From: Contact Centre (CRM) <contact@ribblevalley.gov.uk>
Sent: 06 February 2022 15:32
To: Web Development; Planning
Subject: Planning Application Comments - 3/2022/0031

Planning Application Reference No.: 3/2022/0031

Address of Development: Tanner House farm, Higher Ramsgreave Road, Ramsgreave BB1 9DJ

Re: Planning Application number 3/2022/0031
Resubmission of 3/2021/0963
Tanner House Farm
Higher Ramsgreave Rd

Proposed Granny Annex Layout

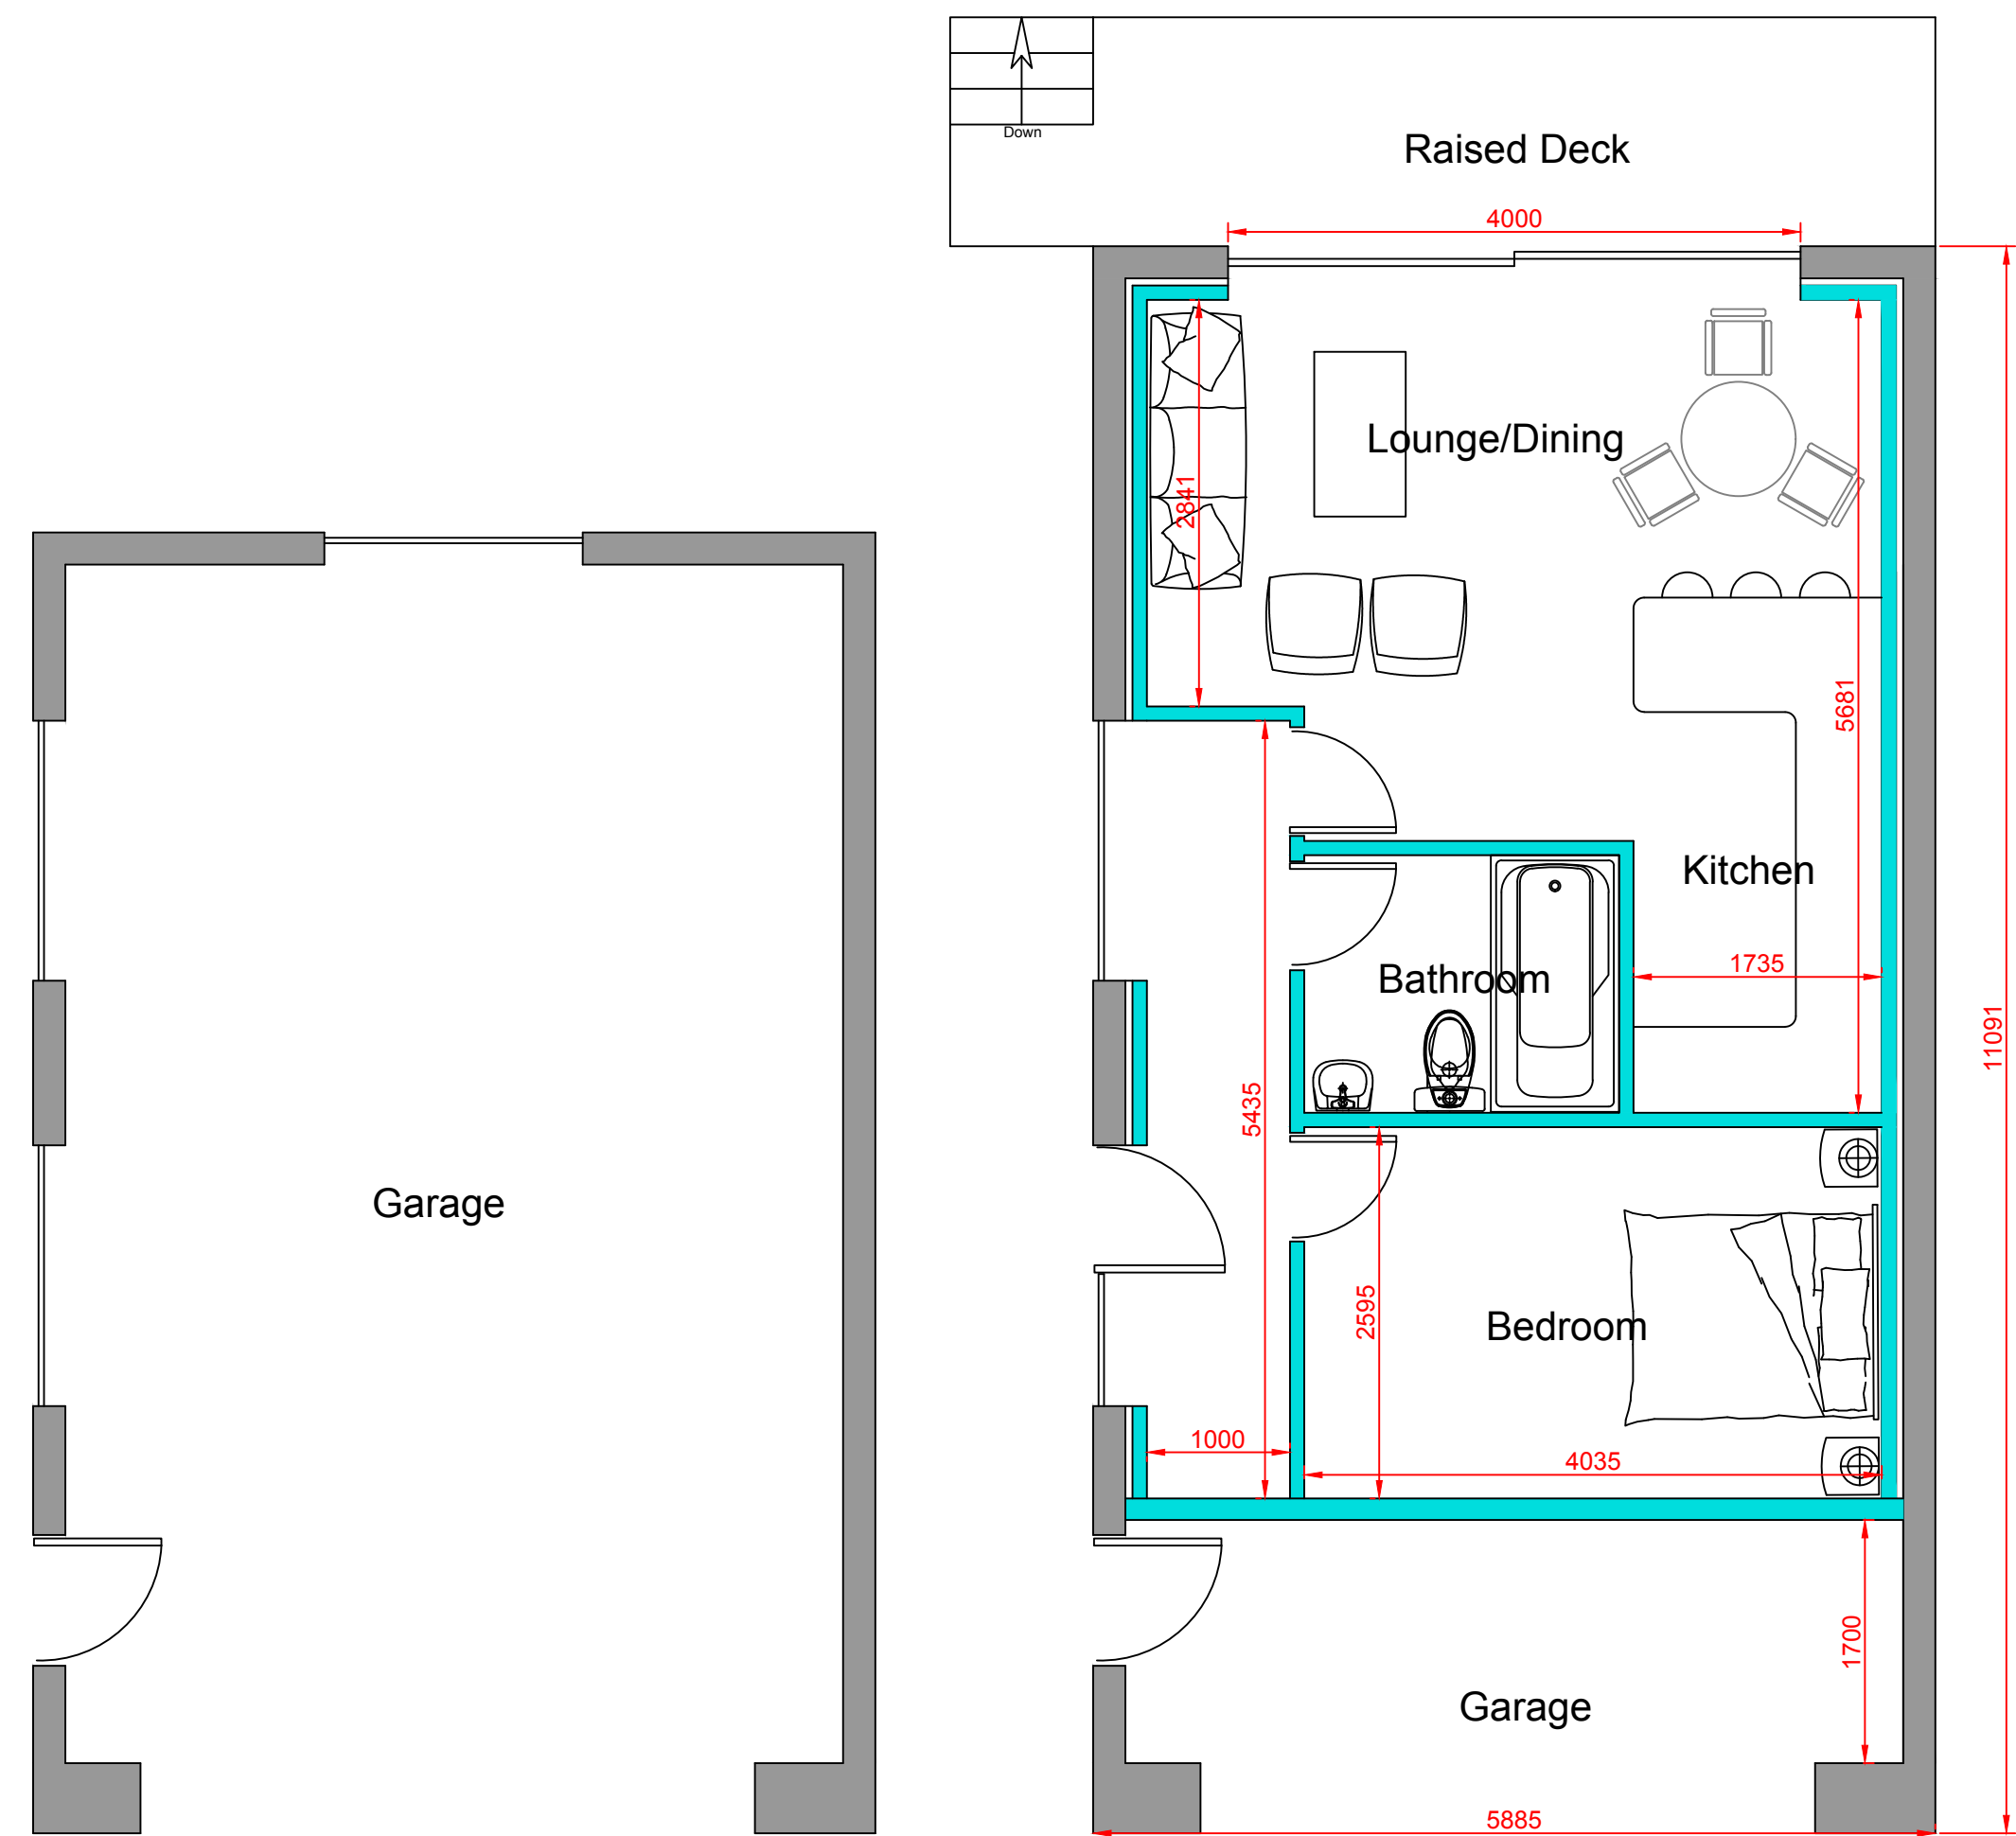
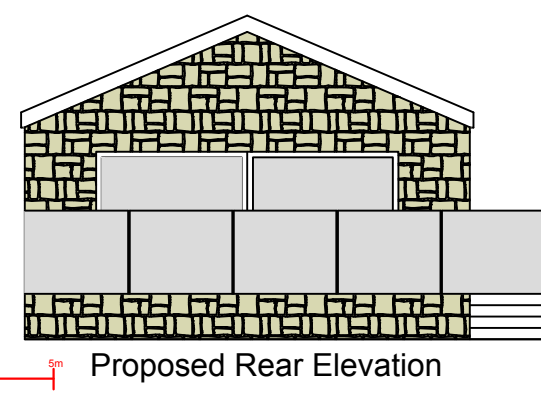
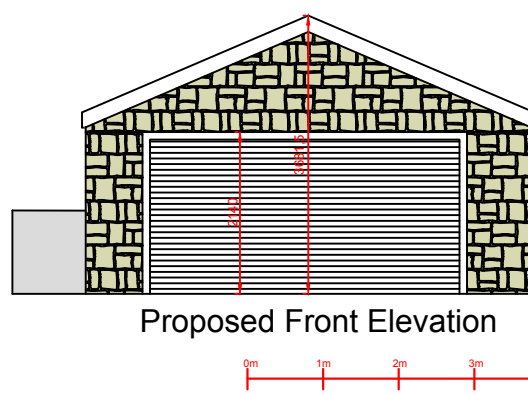
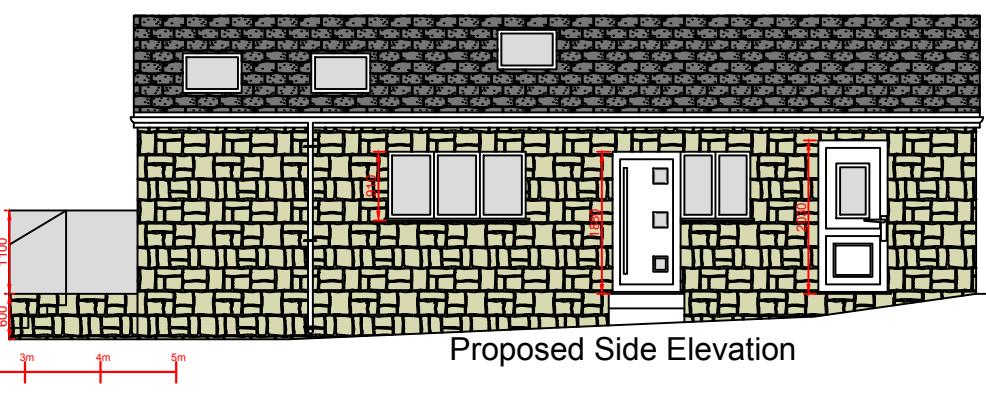
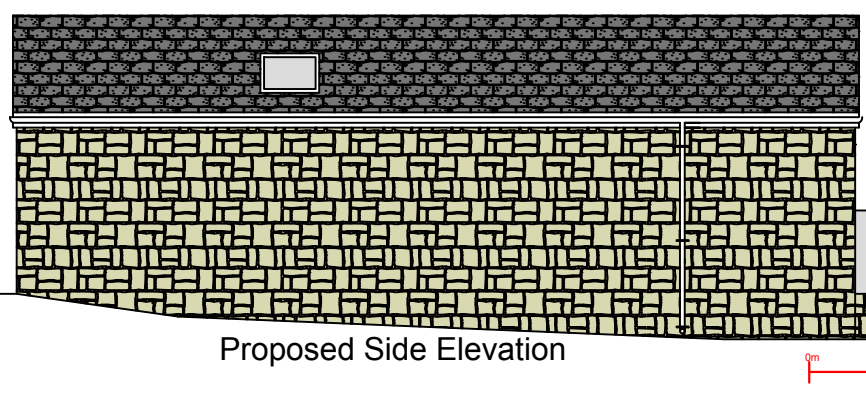
3. The proposal for the Granny annexe is a large extension development. This building is already very close to the boundary wall of number 1 cottage. The extension will again reduce the light into that garden. The alterations that are suggested are not in character with the properties of the area and will result in a visual detriment to the surrounding countryside. It will also affect the residential amenity of neighbouring properties from noise nuisance, light nuisance and privacy. The roof windows are unattractive and very visible from the other properties being single story. The loss of the true garage and space will cause a potential problem and mean extra parked vehicles and the turning circle will be very poor. This loss of the garage would mean that vehicles cannot be parked in or turned around in the proximity of the farmhouse. The main road is 60mph. Often vehicles travel faster, it is on a blind bend and with a very bad blind junction. Manoeuvring vehicles around would be potentially very dangerous. Should future occupants of the annexe also have vehicles this will add to the problem and could cause potential accidents not only to car drivers but pedestrians, horse riders, cyclists and walkers etc with the pavement in front of the farm house and drive entrance being very narrow.
